Environmental Health Consultation Response	Officer	Alan Taylor
---	----------------	--------------------

Detail: Planning request 3/2018/0050

Address:	Great Mitton BB7 9PH			 Ribble Valley Borough Council www.ribblevalley.gov.uk
Application Ref:	38591	Case Officer:	Robert Major	
Response Ref:	/ENV/01	Issue Date:	13 March 2018

Proposed Site Plan - 1:500

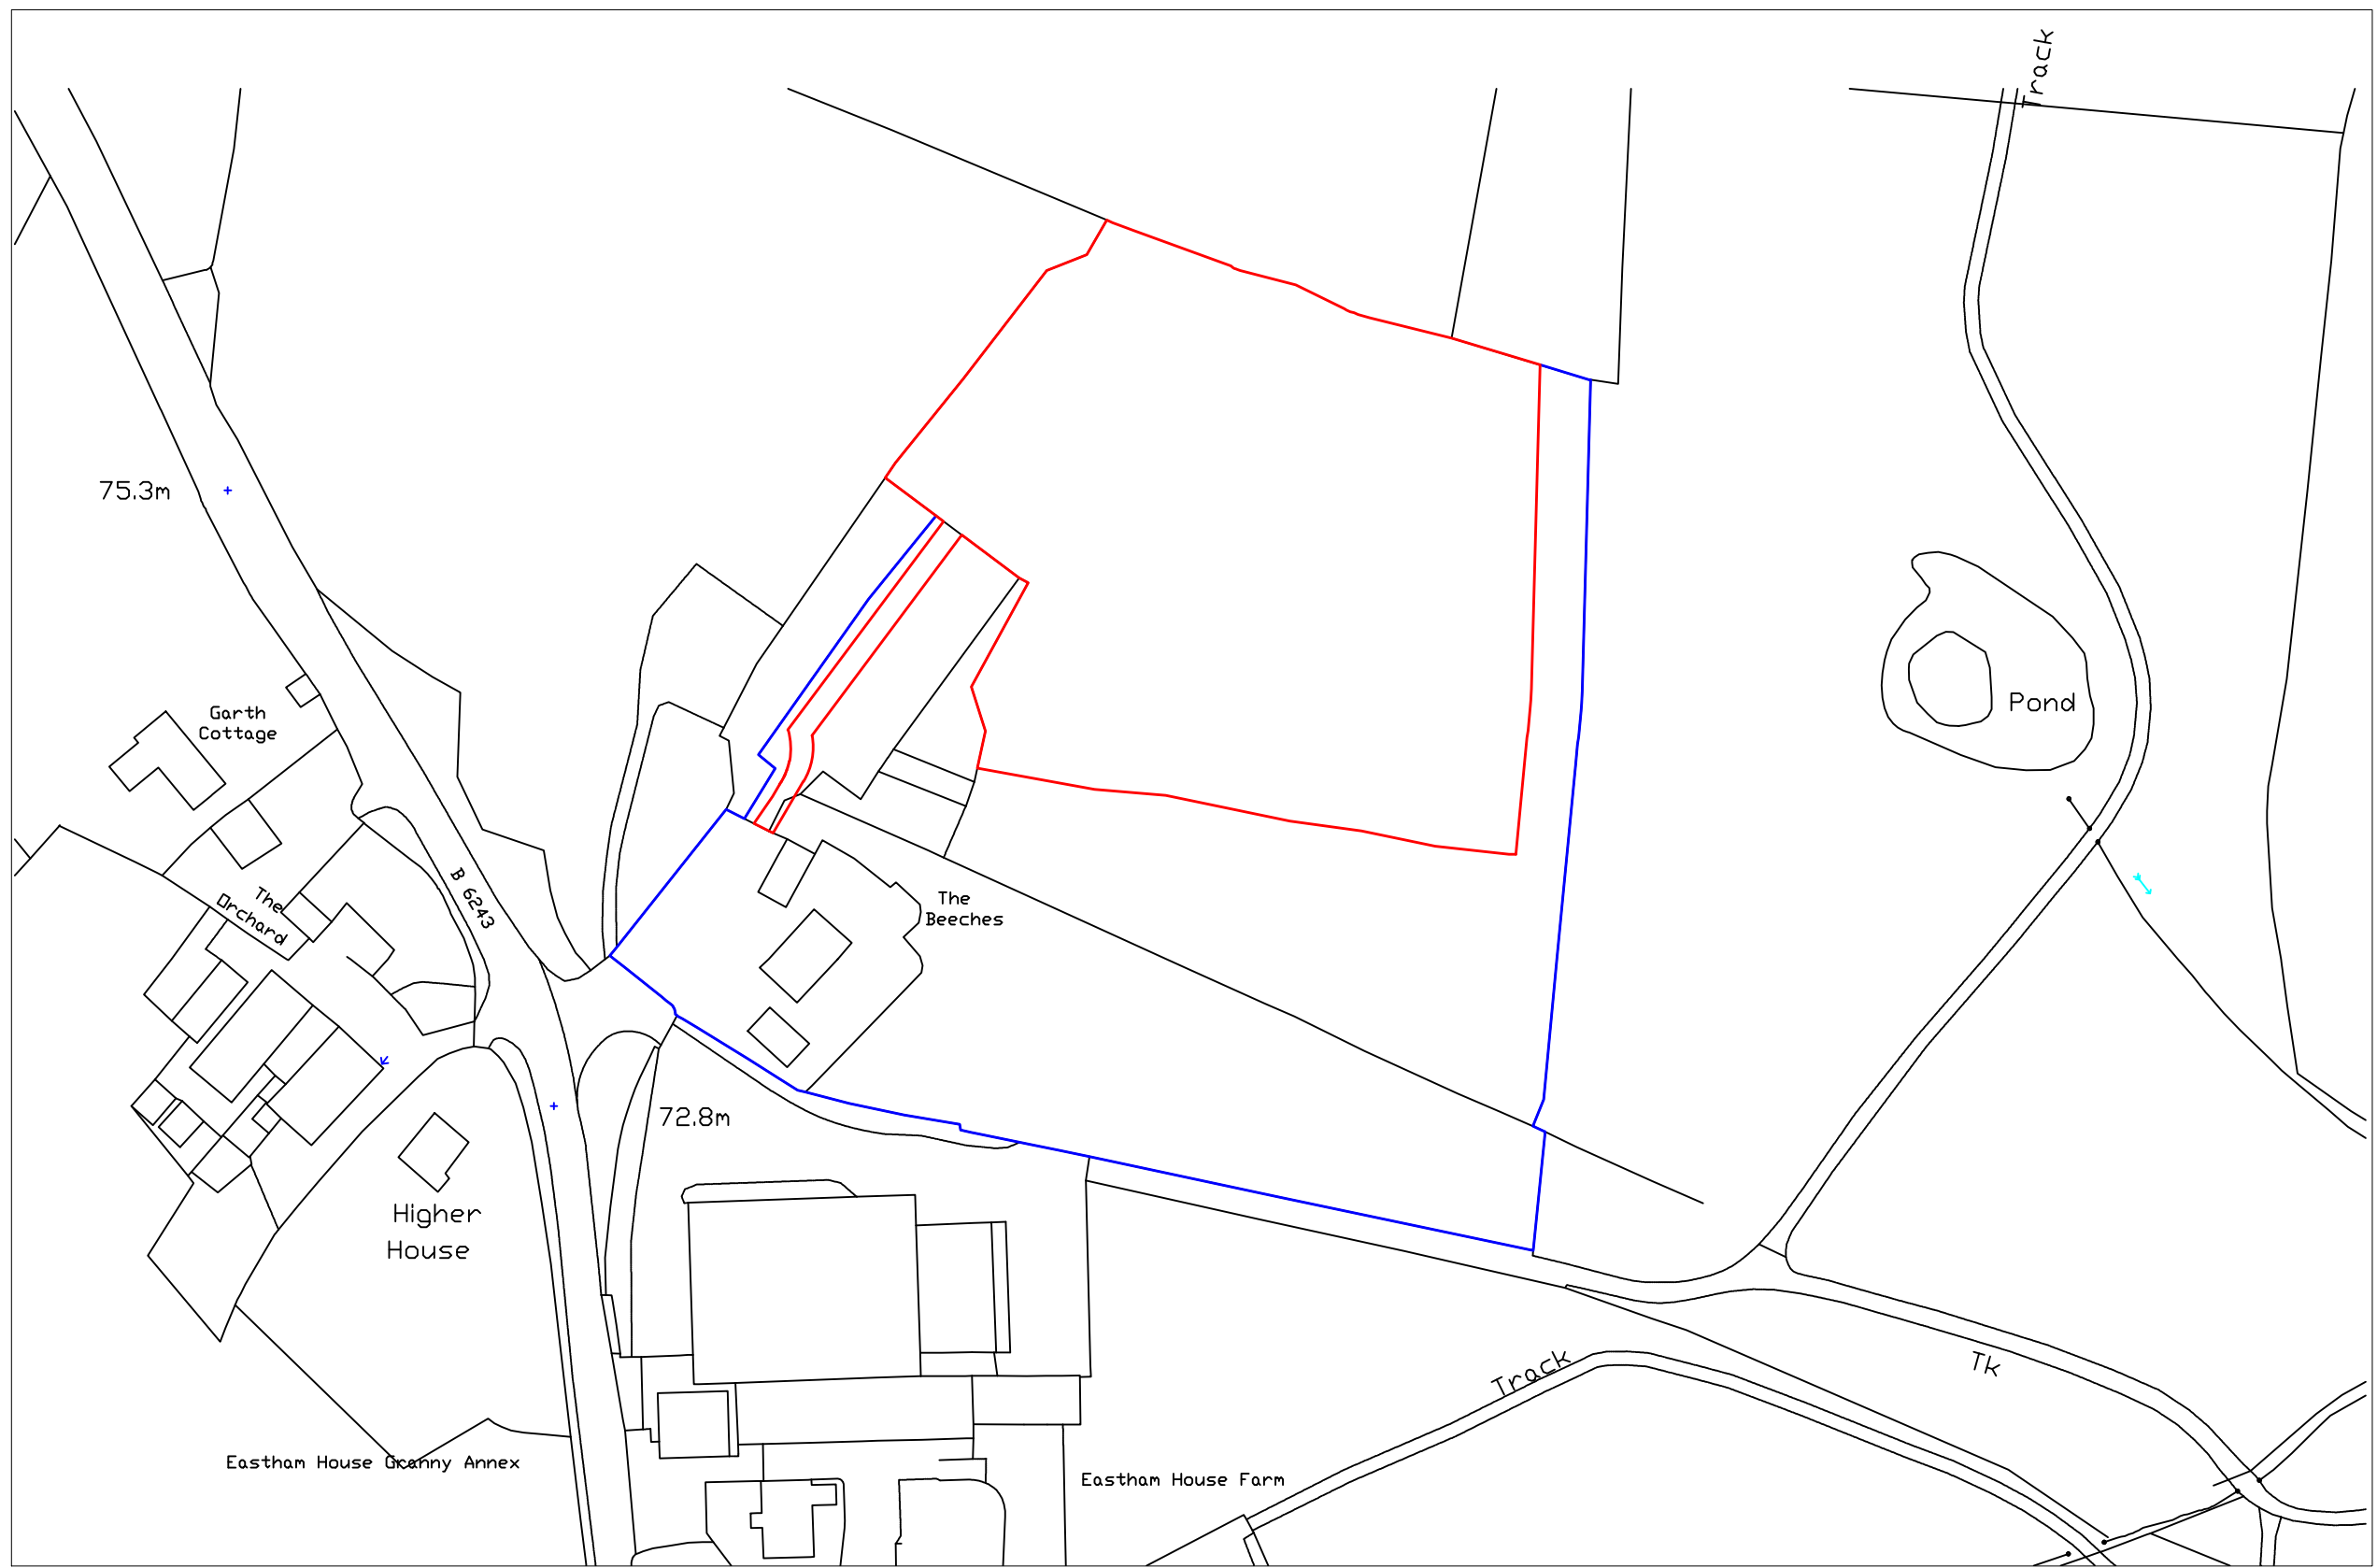
1.2	There is no mention of any lighting to be introduced to the site,
Suggestions/Mitigation	
2.1	The application needs to indicate where the package treatment plant or the soakaway is to be located as there is a water course approximate 150 metres away to the east.

2.5	Any lighting introduced to the proposed site will need to be indicated on the plan to determine if this is likely to cause a nuisance off-site to neighbouring properties?

2.9	Should you be minded to approve the application, notwithstanding other considerations, I would suggest that the following conditions be attached should you feel they are relevant and justified: • The application need to inform the location of the package treatment plant and location of the soakaway. • Operating hours need indicated/conditioning. • Any lighting introduced to the site need to be directed to ensure no light escapes the boundary of the proposed site. • If unchlorinated water is to be utilised, then a suitable water treatment plant must be installed to ensure the water complies with the requirements of the Private Water Supply Regulations 2016.
